Application number: 2024/91277	
What is the application for?:	Erection of two storey side and single storey rear extensions with associated al
Address of the site or building:	3, Field Head, Shepley, Huddersfield, HD8 8DR
Postcode:	HD8 8DR

Type of comment: An objection	
Do you wish your comments to be published on the website anonymously?	No

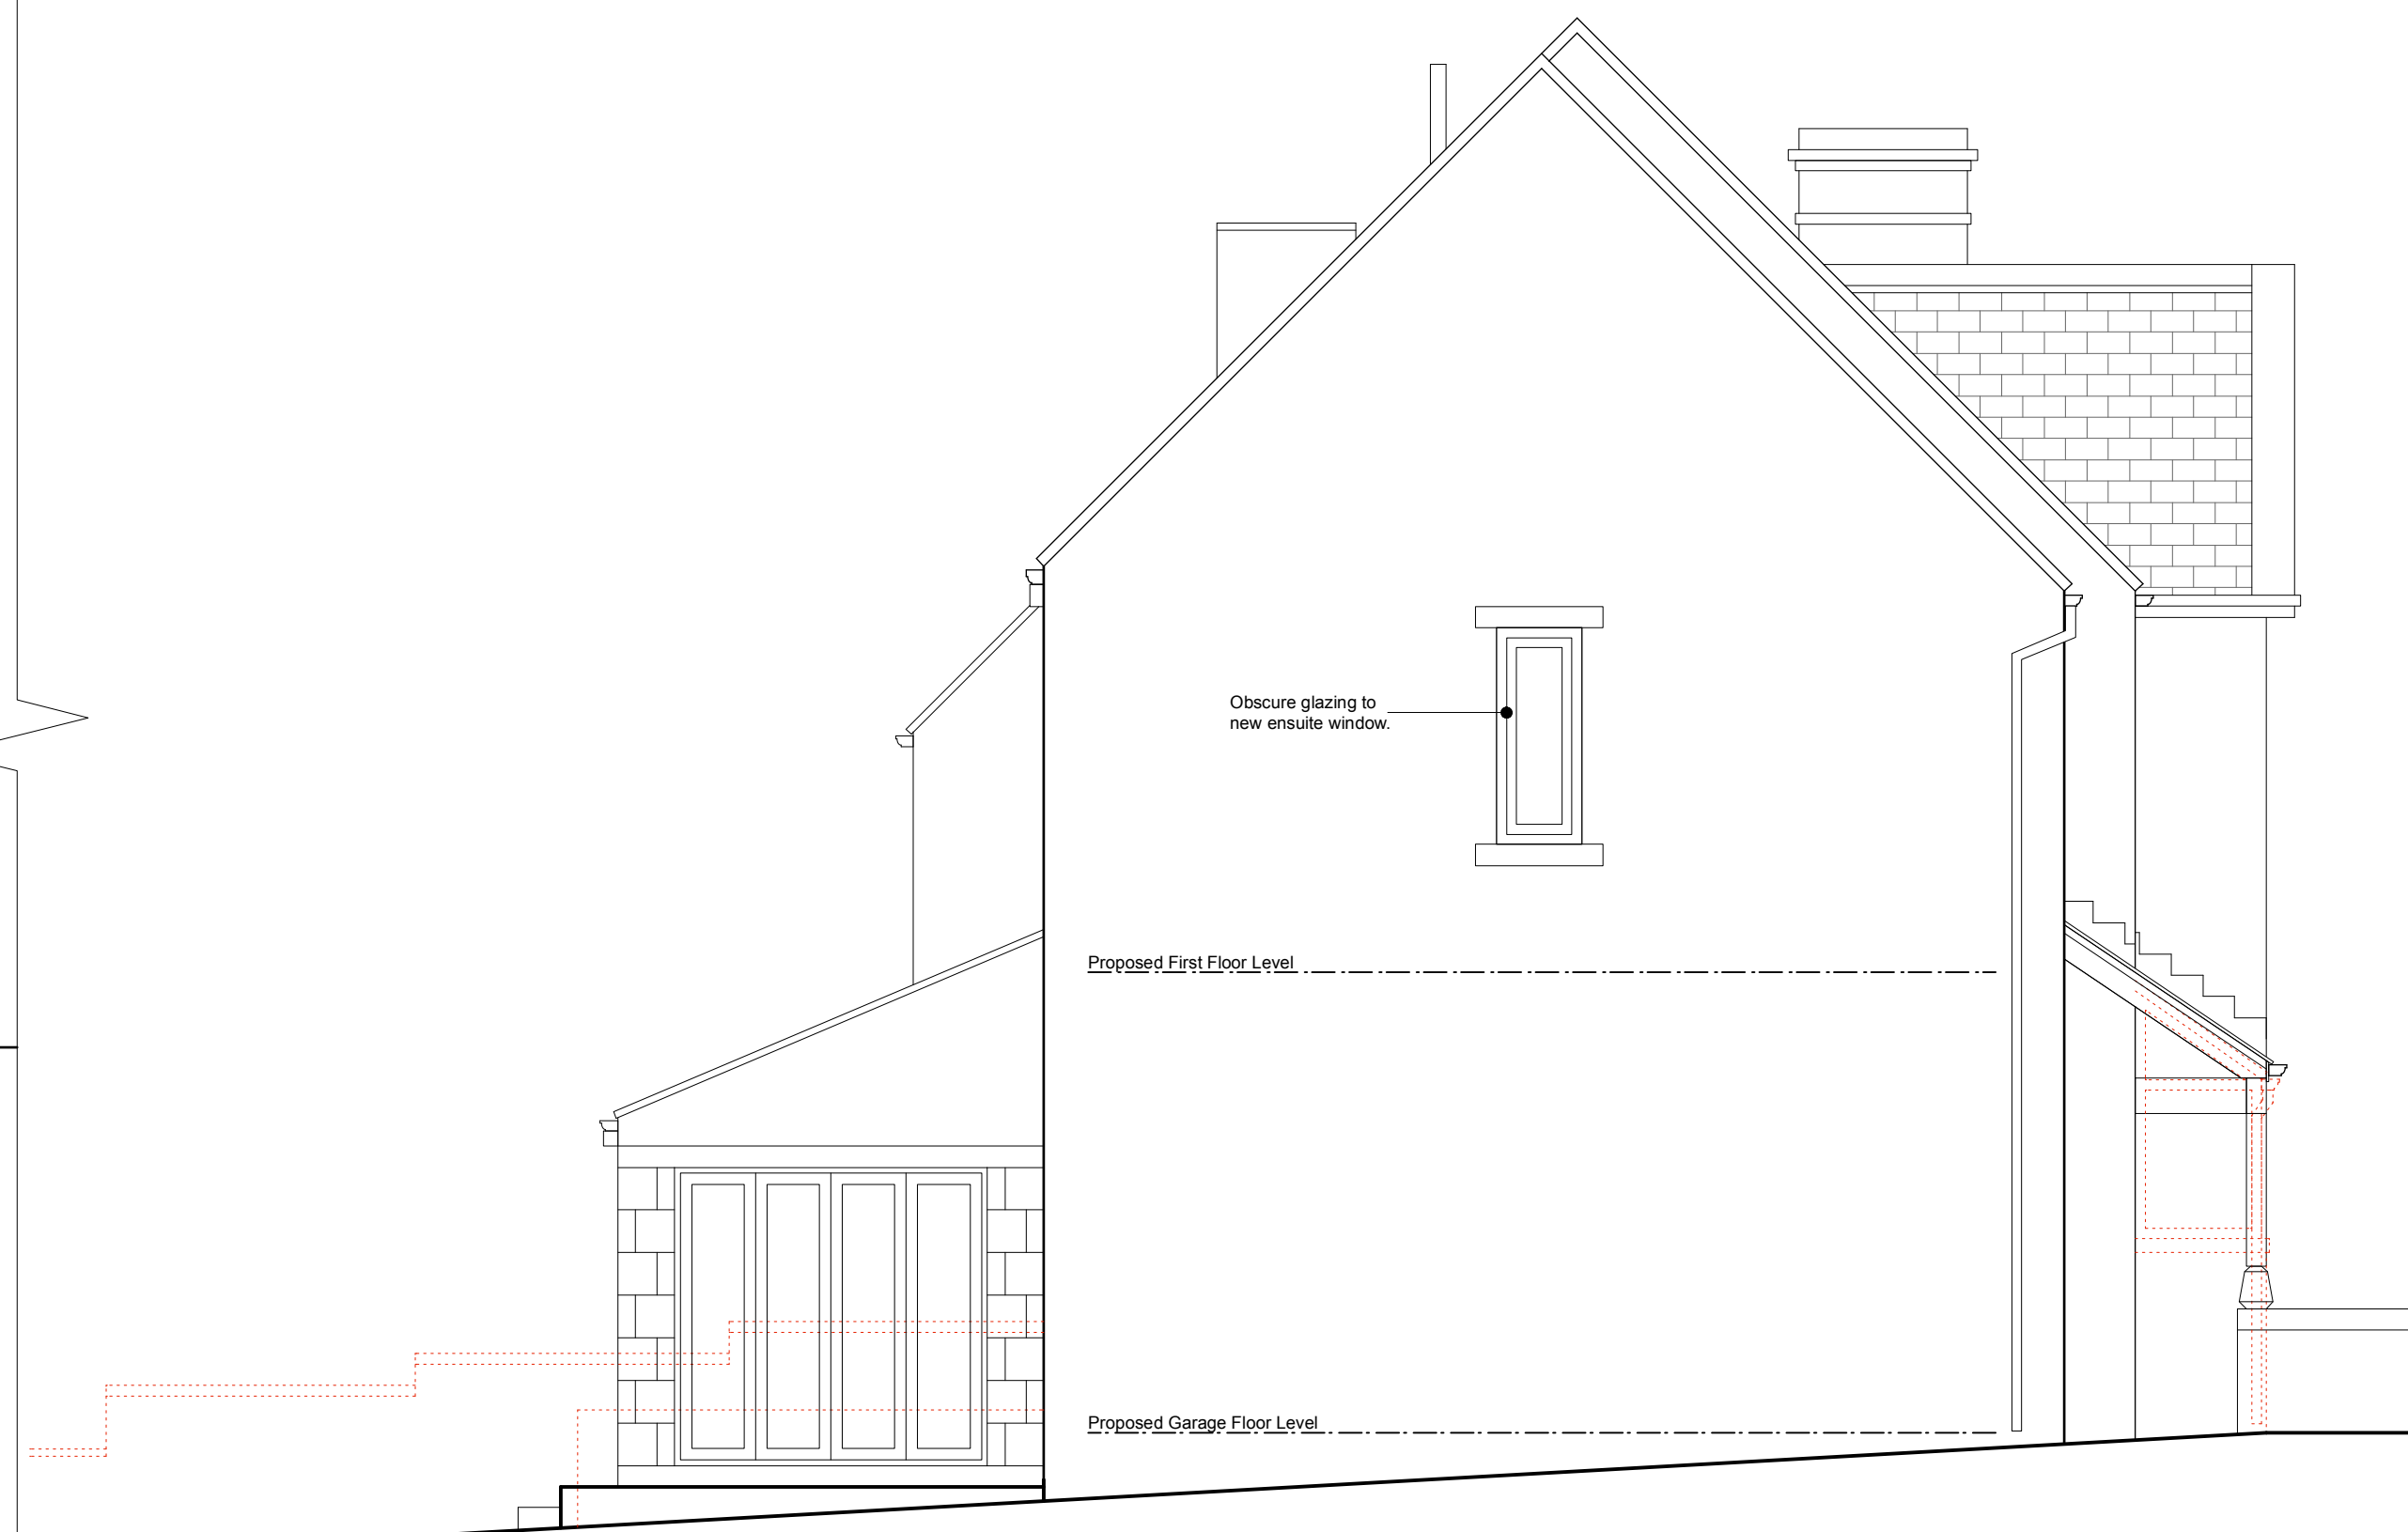
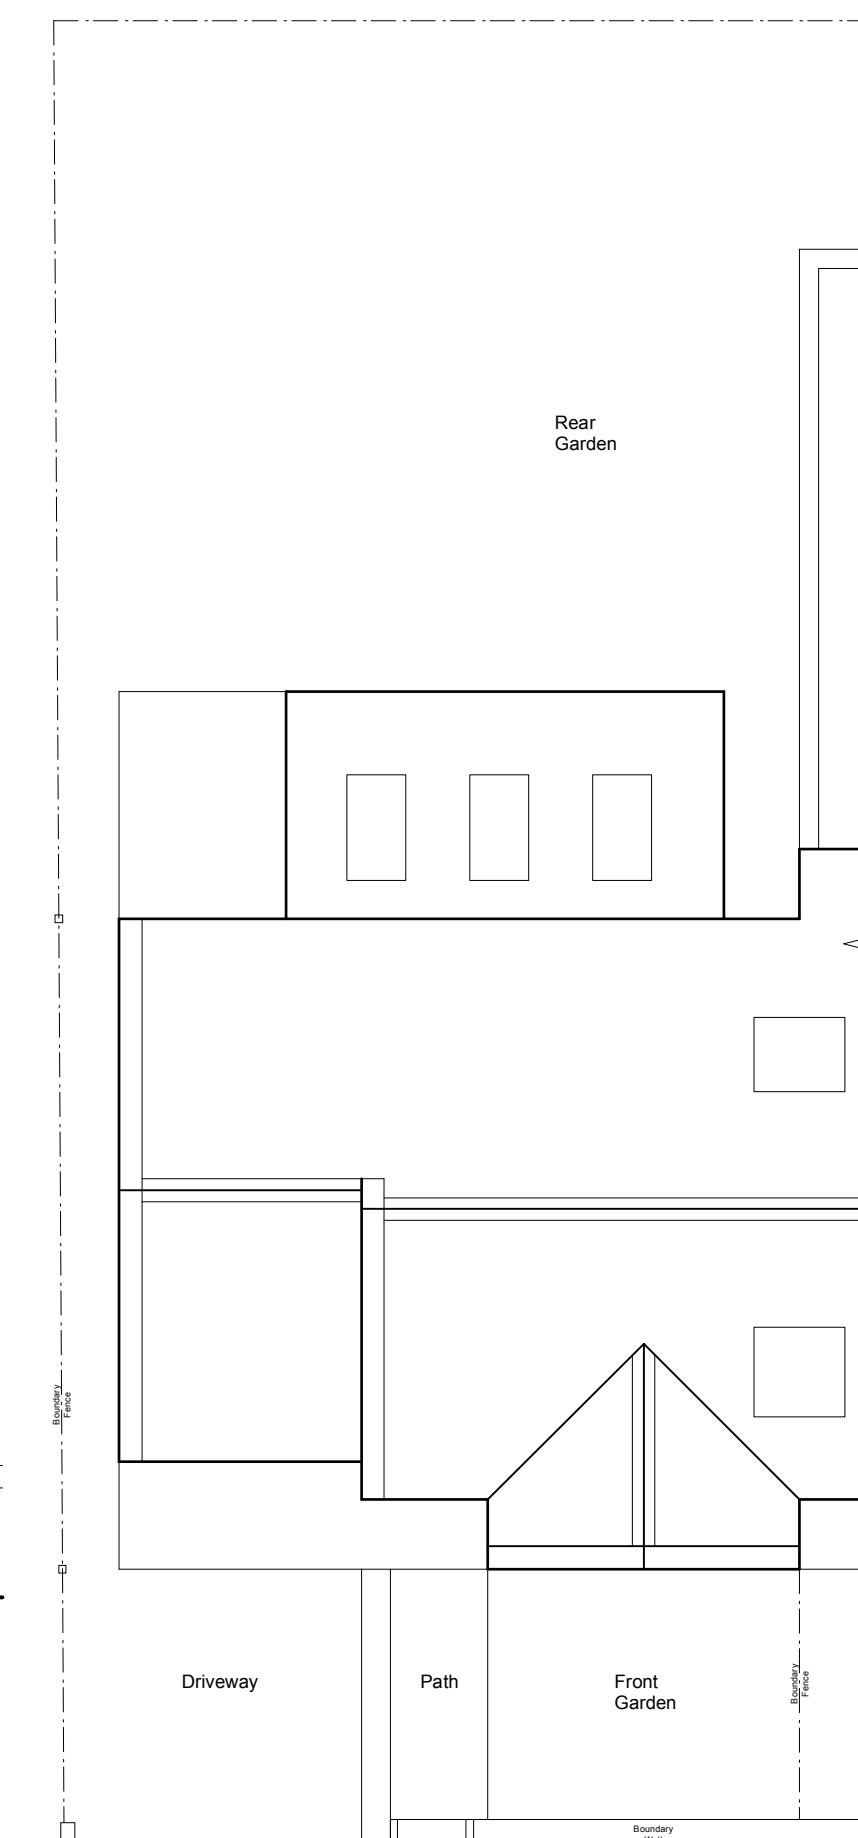
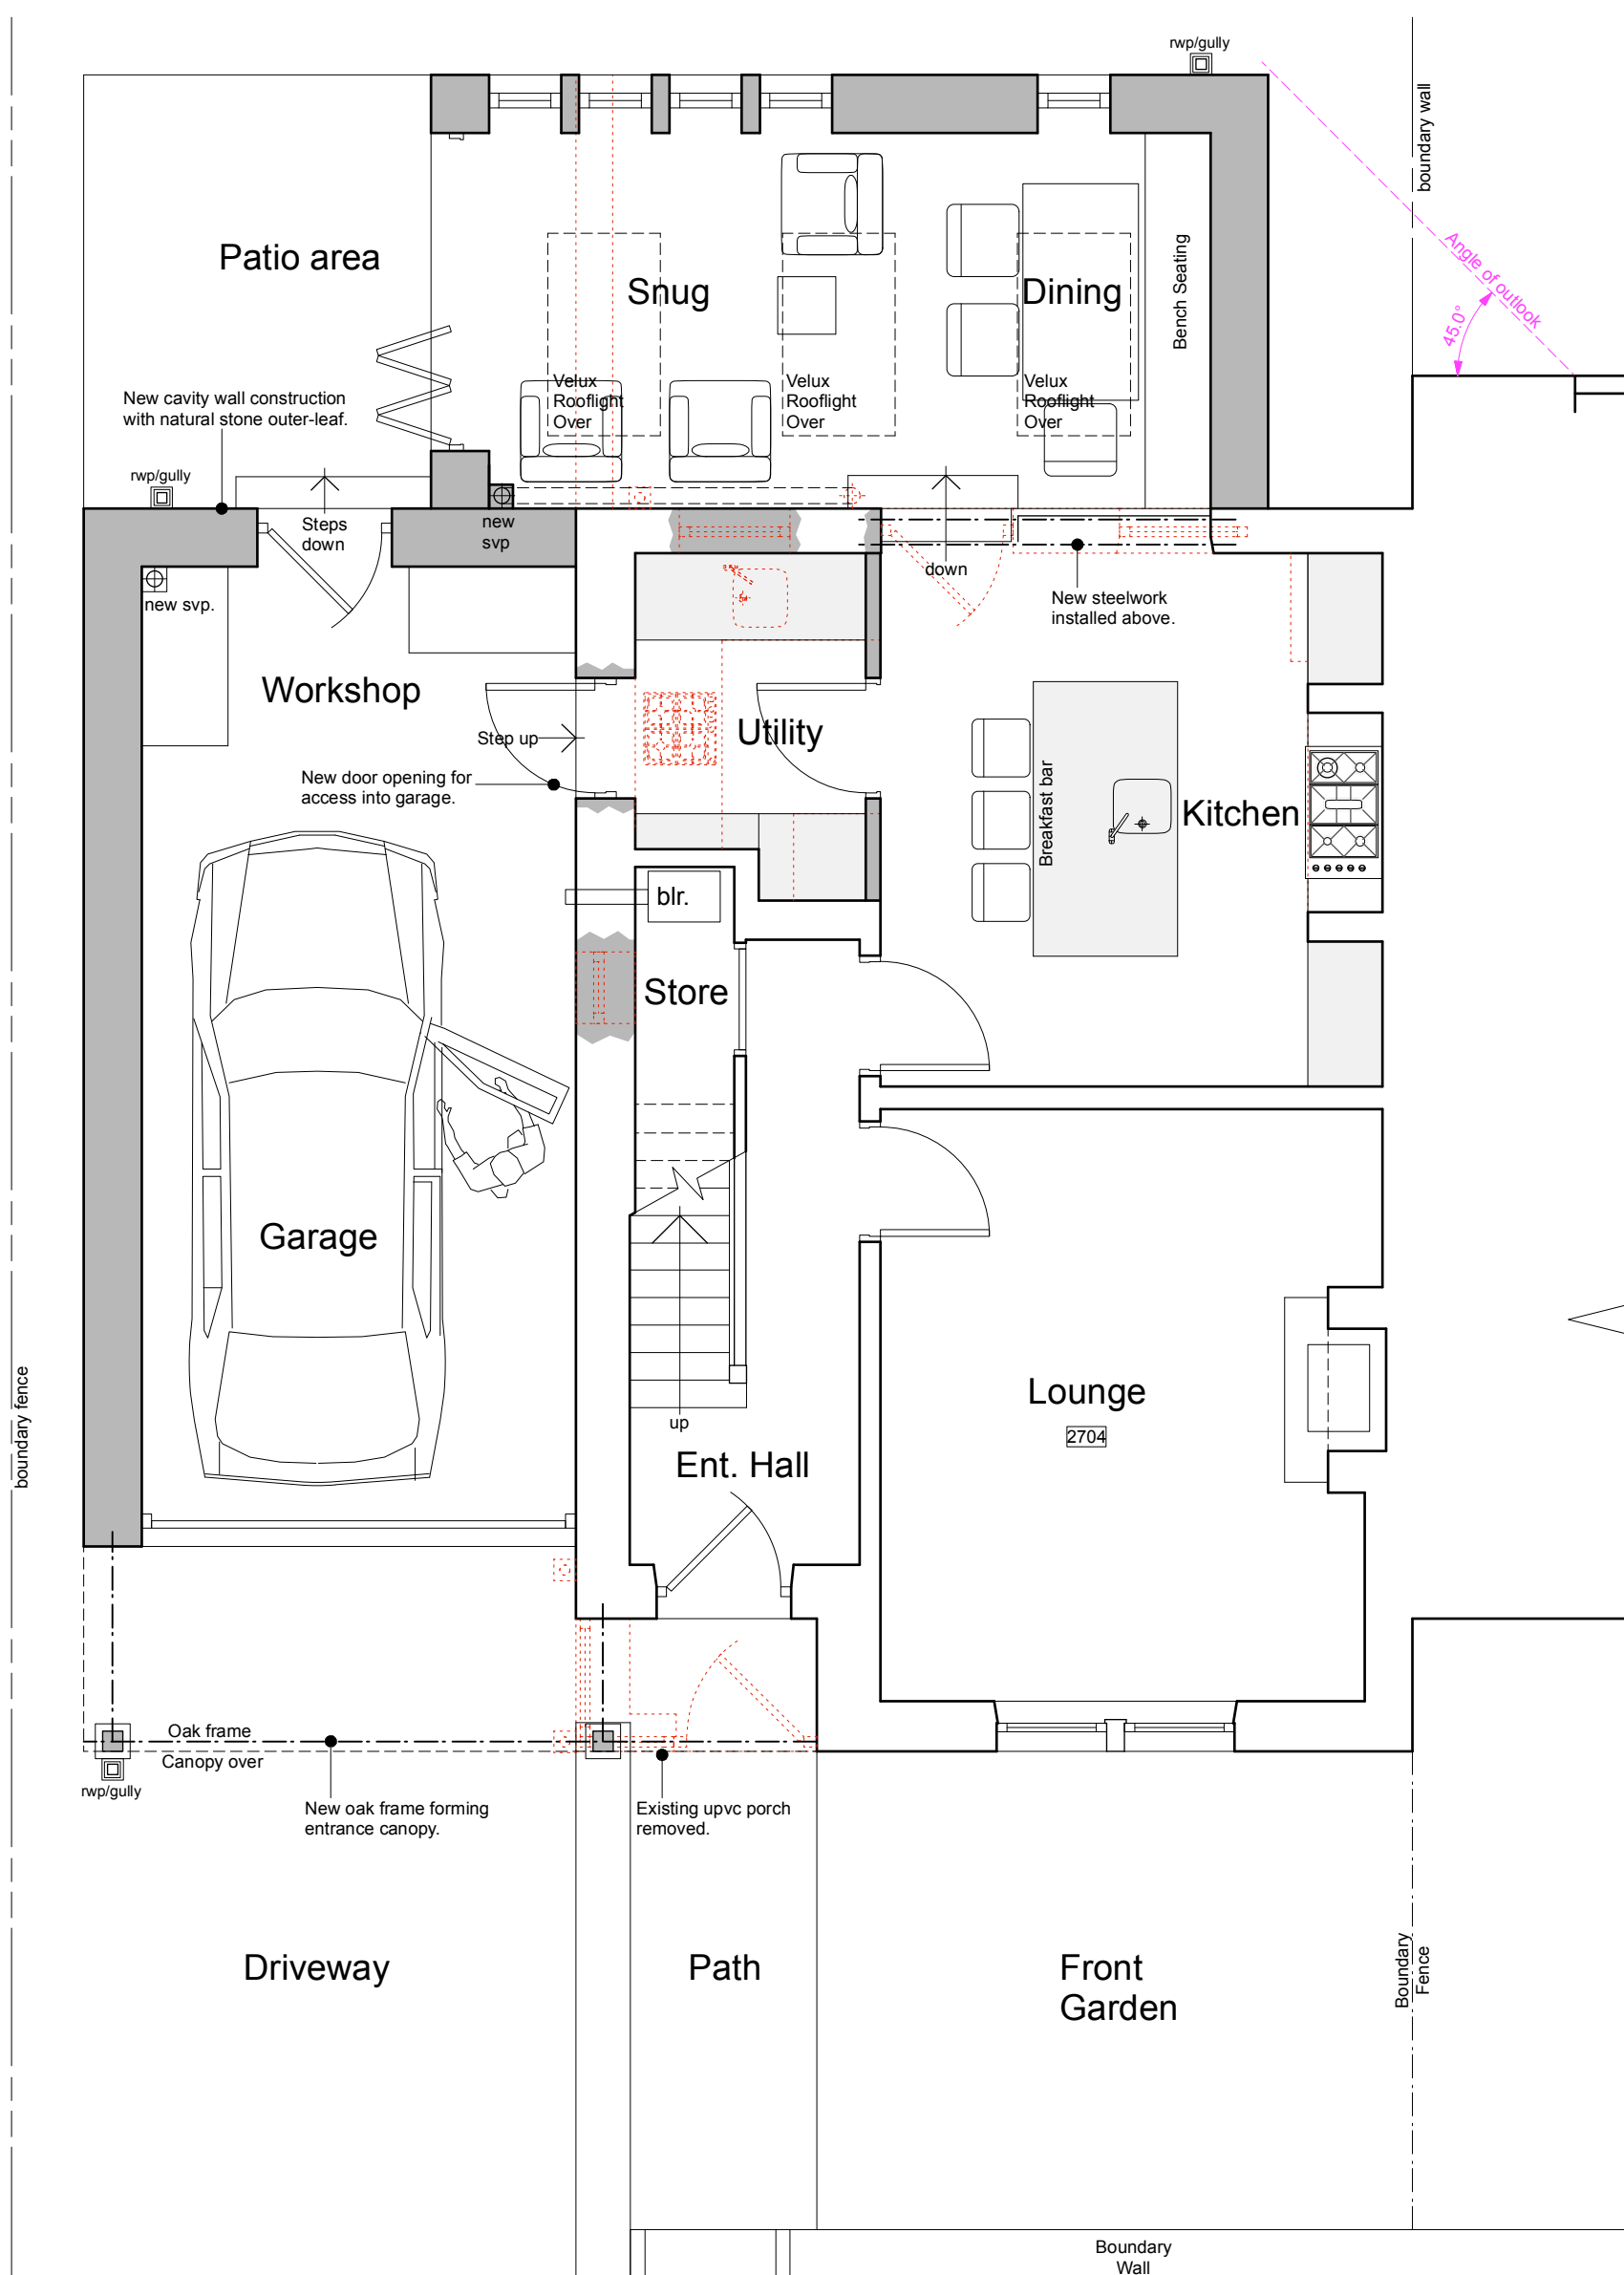
- 1) The design will break the 45 degree rule for extensions. The extension will be within the 45degree line drawn from the nearest edge of the neighbouring window.

- 3) The proposed application will cause a significant and unhealthy reduction in sunlight into my property/garden and other neighbouring properties (currently my garden receives sunlight until 8-9pm) this application will mean that sunlight is restricted from 6pm. often sits in the garden to get some sunshine and vitamin D. This will negatively impact the health and wellbeing of the residents.

- 5) The proposed rear extension will be within 10-15ft of my kitchen and dining room, significantly impacting privacy with a direct view into the property from a close distance. The rear extension will also overlook directly into the garden which removes all privacy of the residents within their garden, again significantly impacting health and wellbeing of the residents. This will cause overshadowing to my property.
